To Protect and Promote the Health and the Environment of the People of Kittitas County

January 21, 2009

RE: Clint Short Plat (SP-08-00054)

SHORT PLAT NO. _____
KITITAS COUNTY, WASHINGTON

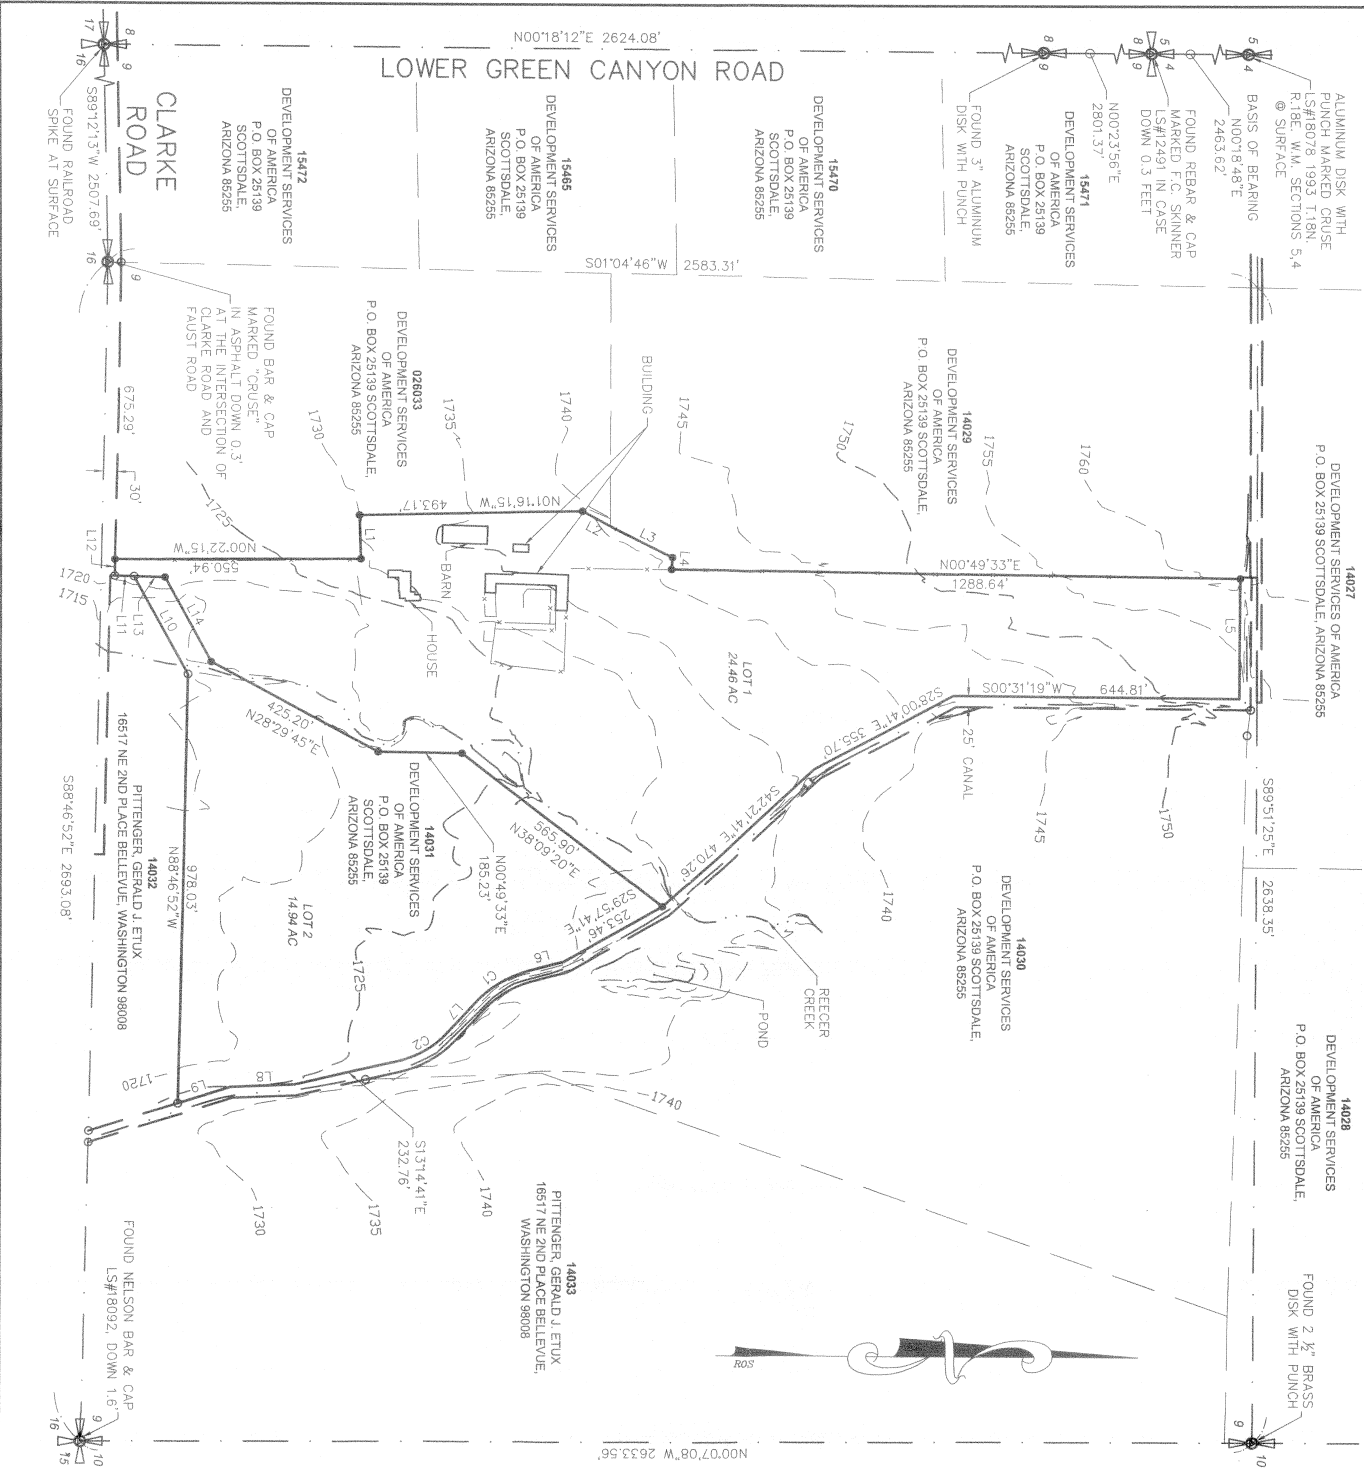
- Please have the applicant re-submit the plat drawing to reflect the location of the existing well.
- The potable water plat note is incorrect (plat note #6). Please replace the plat note with the following:

"The approval of this division of land includes no guarantee that there is a legal right to withdraw groundwater within the land division. The approval of this division of land provides no guarantee that use of water under the ground water exemption (RCW 90.44.050) for this plat or any portion thereof will not be subject to curtailment by the Department of Ecology or a court of law. "

- Please also include the following plat note:

"Metering will be required on all residential well connections and metering results shall be recorded in a manner consistent with Kittitas County and Washington State Department of Ecology requirements."
